The **Arun Conservation Area Advisory Panel** wish the following comments to be taken into account in the determination of the applications:

AB/129/25/HH - 8 Nineveh Shipyard, Arundel

Objection

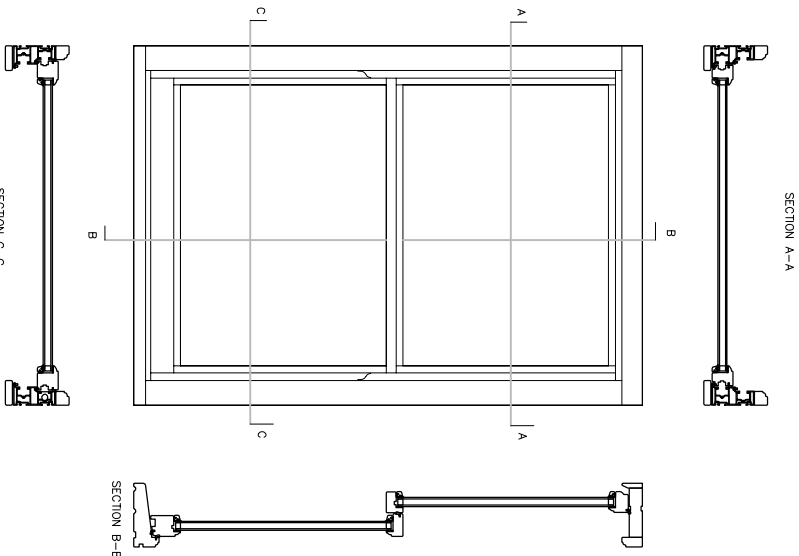
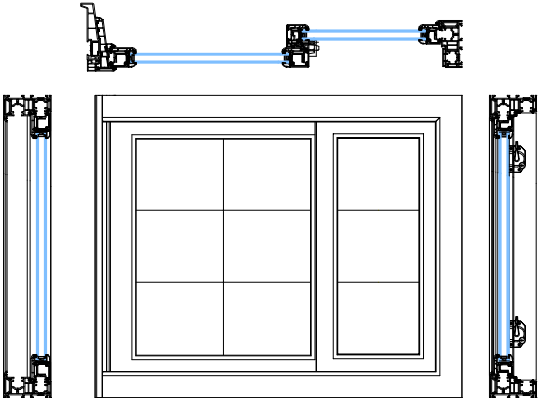
For this reason, and the designated heritage asset context, the use of pvcu fenestration, which lacks the finish and subtlety of painted timber is considered inappropriate. The existing windows also have fully formed glazing bars which will either be missing or substituted with inappropriate false 'stick on' ones in the new fenestration, further detracting from the appearance of the building and the conservation area.

If the windows need to be replaced then they should be replaced in painted timber and match the originals in detail and opening mechanism.
